# Rezoning Transportation Analysis

Petition Number: 2019-180

Date	Description
01-14-2020	First Review
02-11-2020	Second Review
08-25-2020	Third Review (LJensen)

**RZ-2.0**

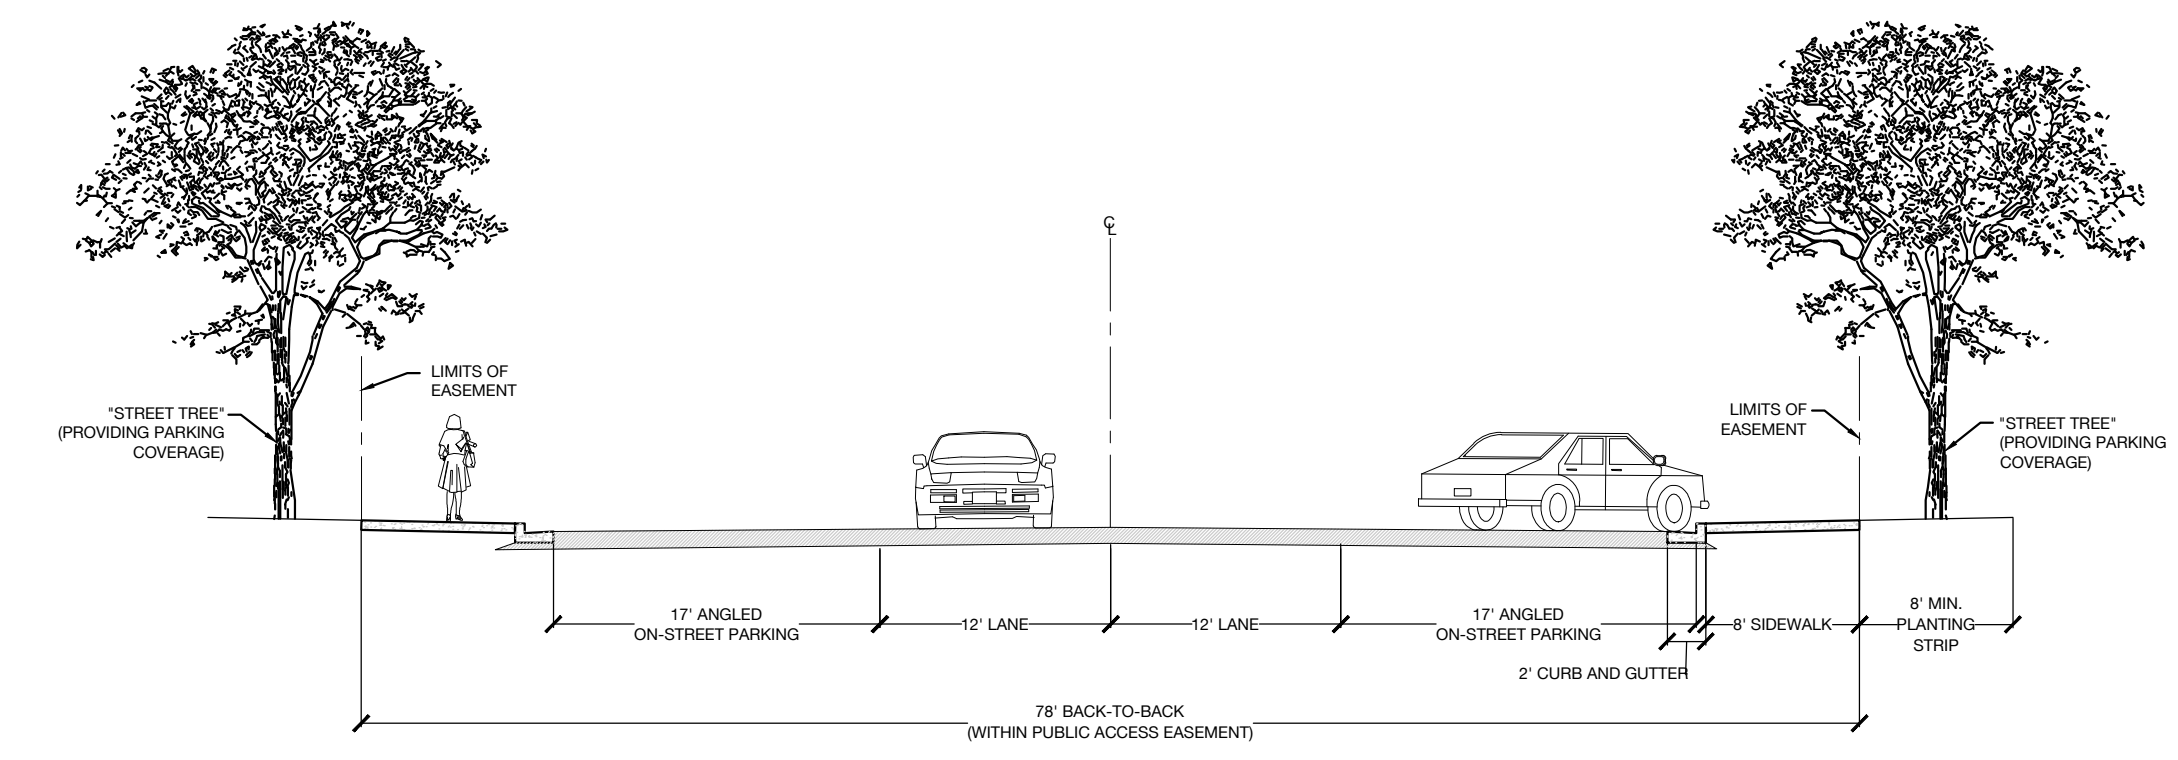
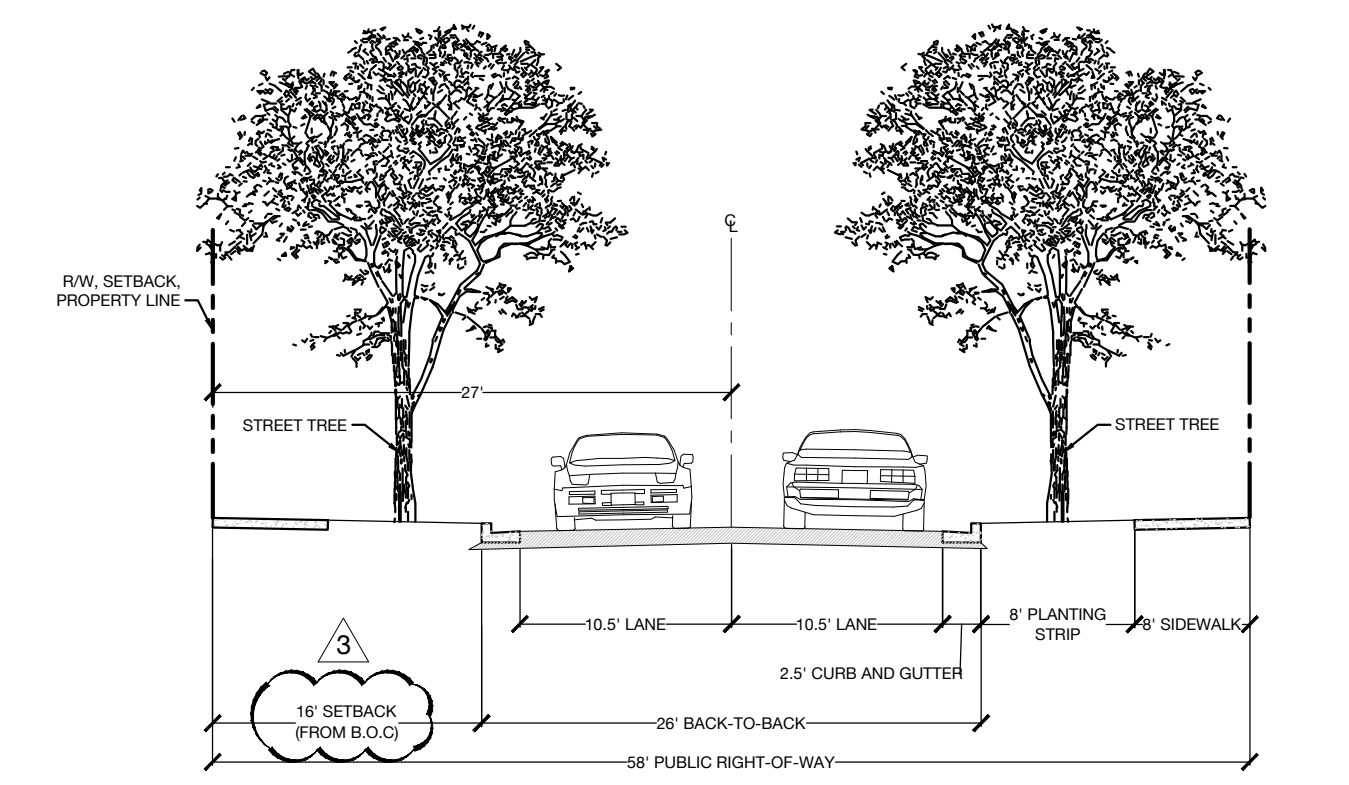
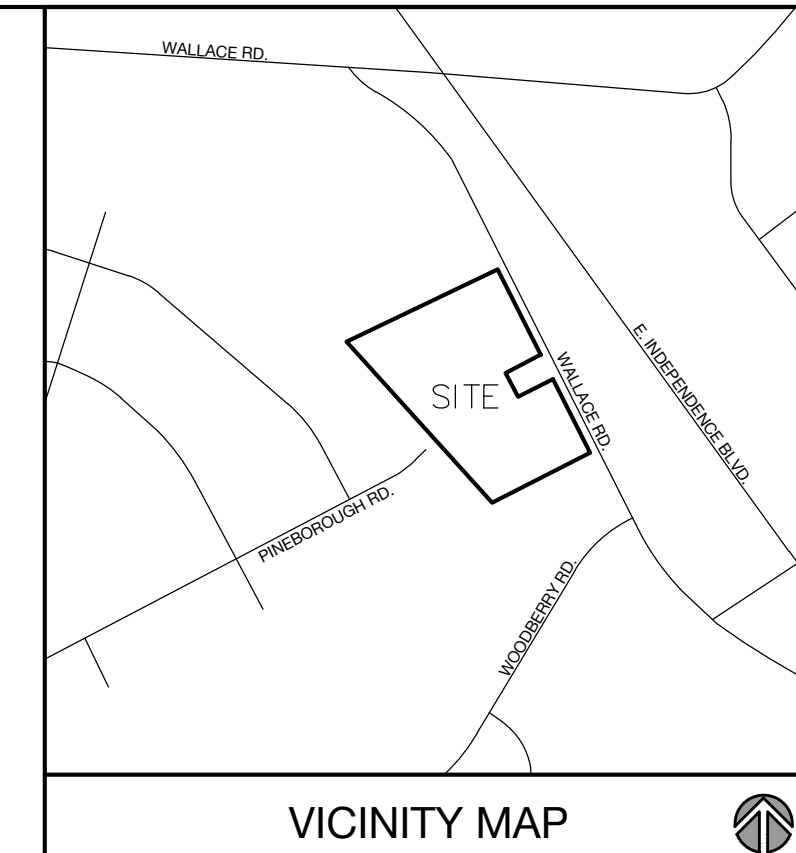
1. **Curblines:** The proposed zoning district has a setback measured from back of the existing or proposed future curbline.
  - a. ~~Wallace Road:~~ The proposed back of curb is 25.5' from the centerline of Wallace Road including half the 12' median, 11' travel lane, 6' bike lane, 2.5' curb and gutter, 14' planting strip, and 6' sidewalk.
  - b. ~~Pineborough Road:~~ The cross section the petitioner has provided, 58' from back of sidewalk to back of sidewalk, is sufficient.

The site plan should show the curb and gutter labeled and dimensioned from the centerline for each road.

3. ~~Chapter 19 Ordinance~~ requires the curb and gutter be constructed in its future location. The petitioner should continue the existing curb and gutter on Wallace Road.

REZONING PETITION #2019-180

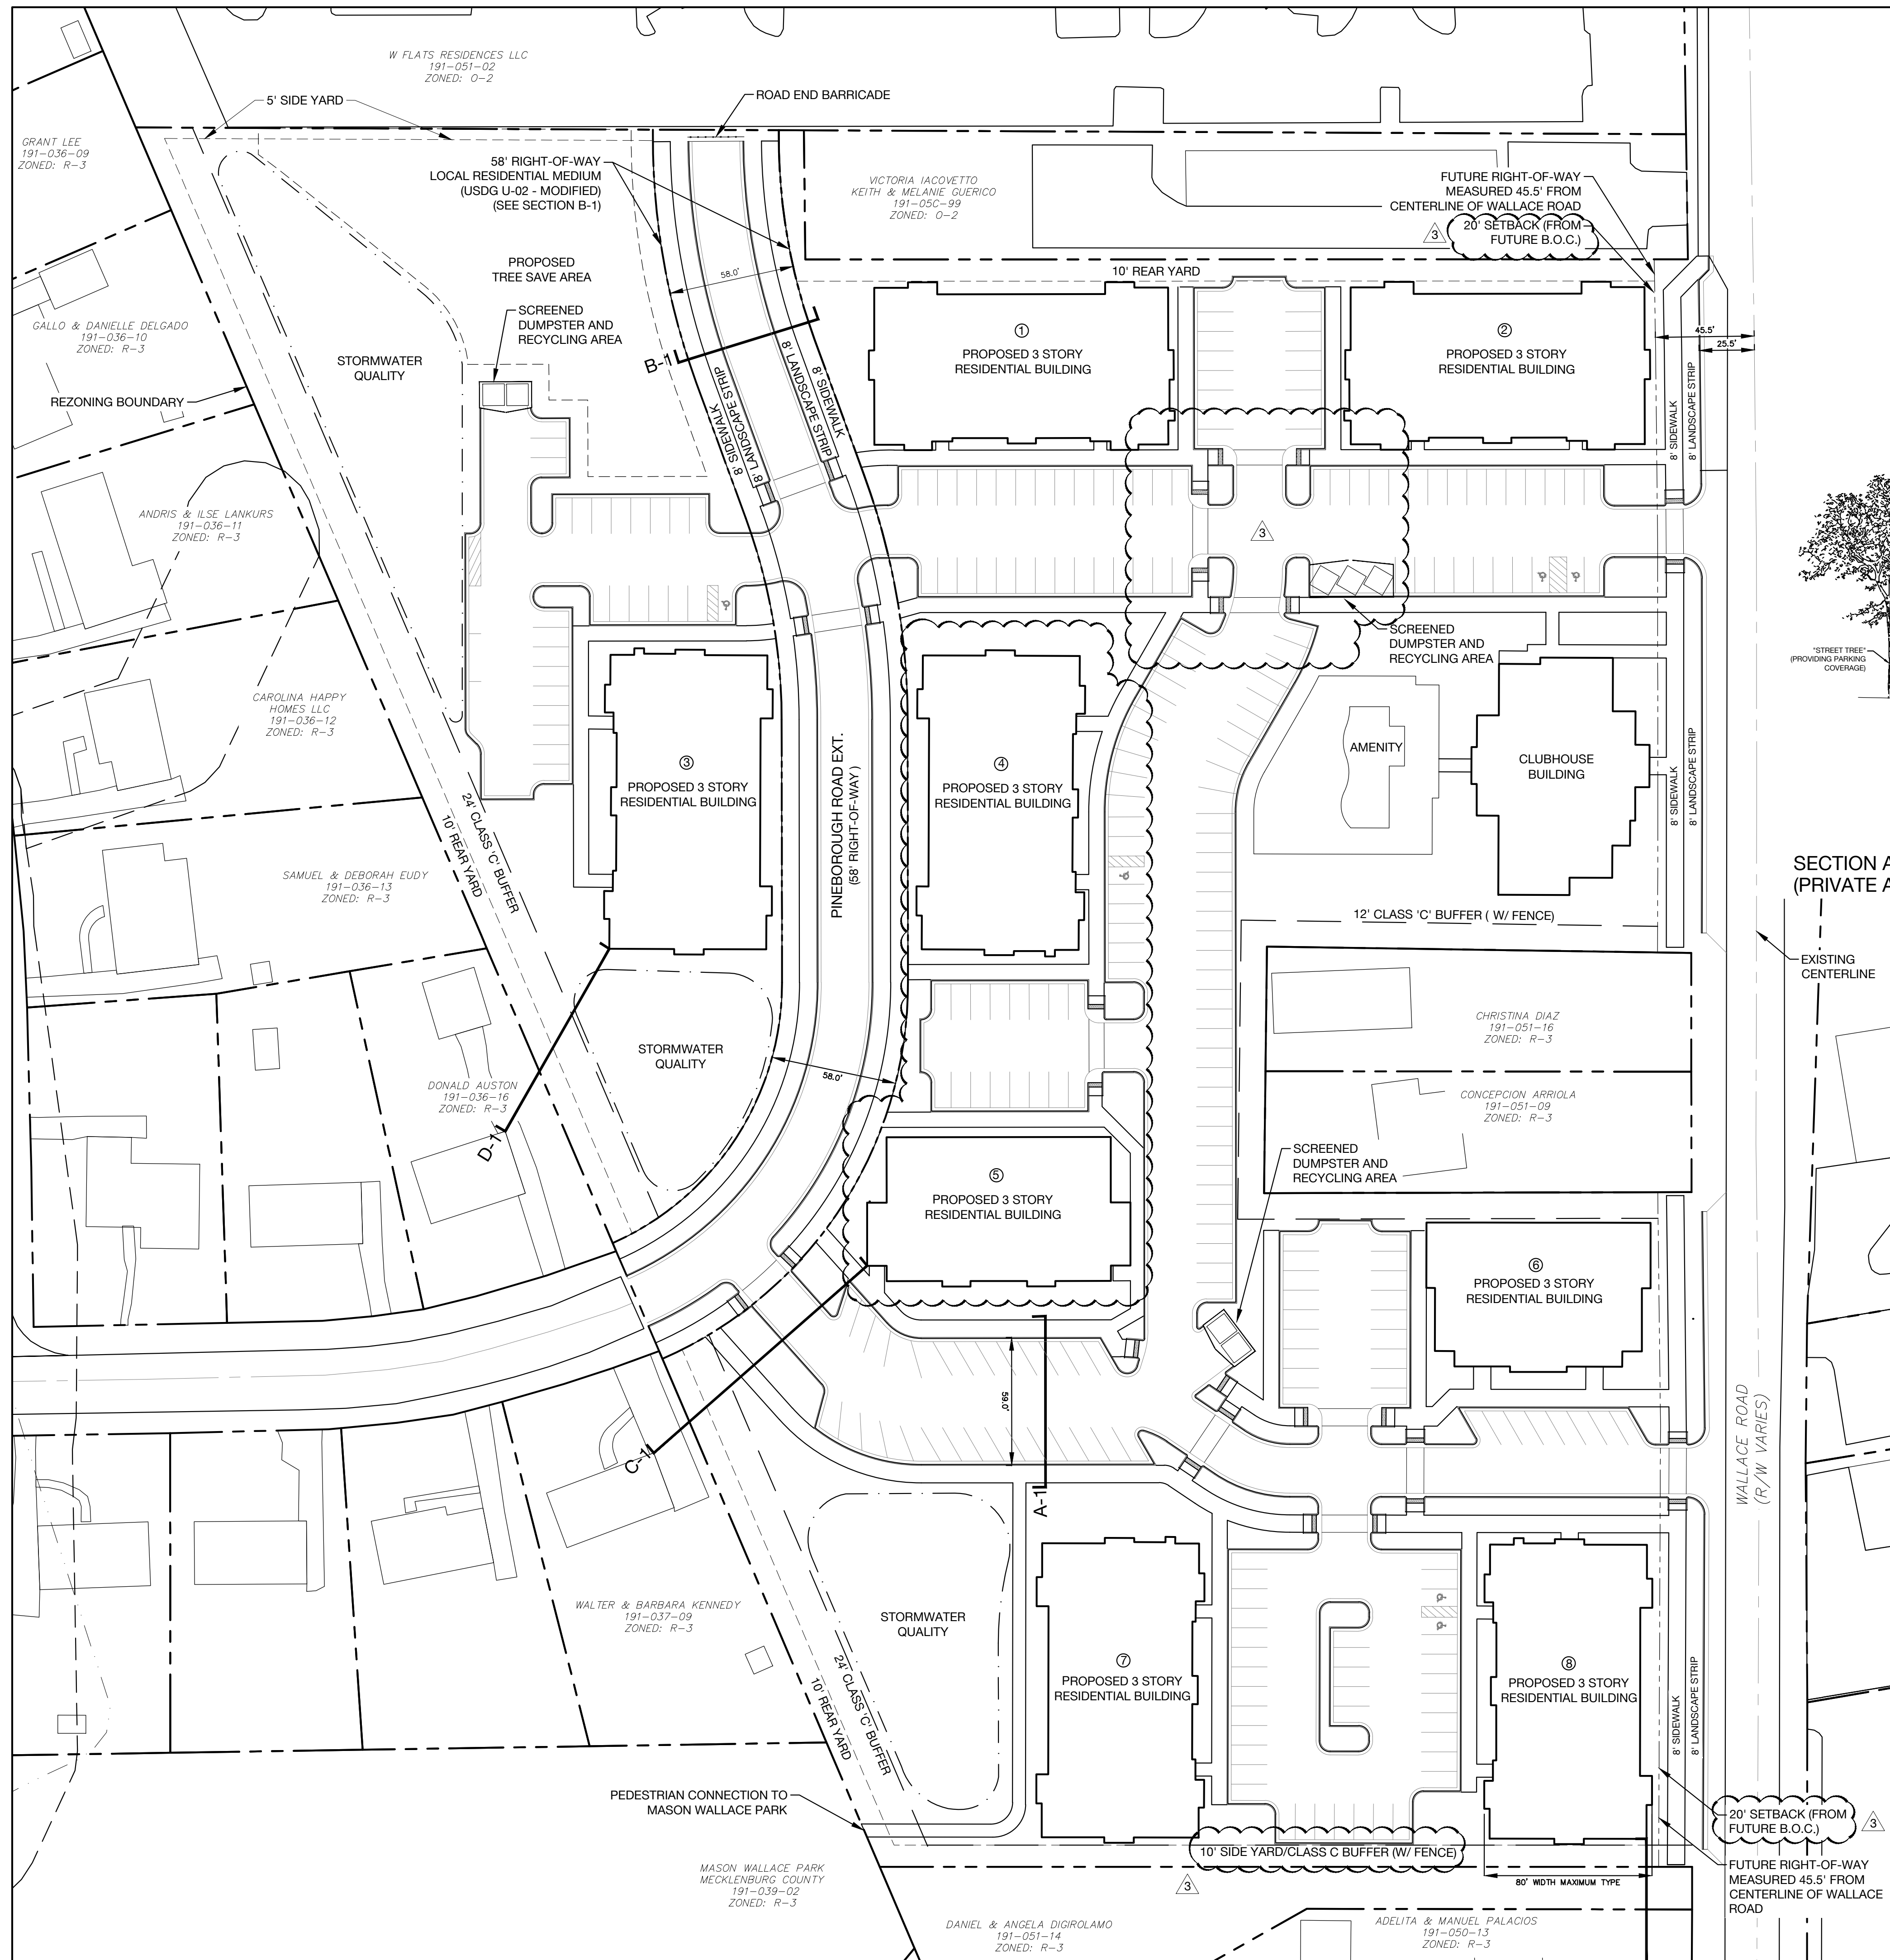
7. The petitioner should revise the site plan to add a note specifying dedication and fee simple conveyance of all rights of way to the City before the site's first building certificate of occupancy is issued. CDOT requests right of way set at 2' behind back of sidewalk where feasible.

8. The petitioner should revise the site plan to add a note specifying all transportation improvements will be approved and constructed before the site's first building certificate of occupancy is issued. The petitioner may phase transportation improvements if said improvements and phasing are explicitly described in site plan notes.
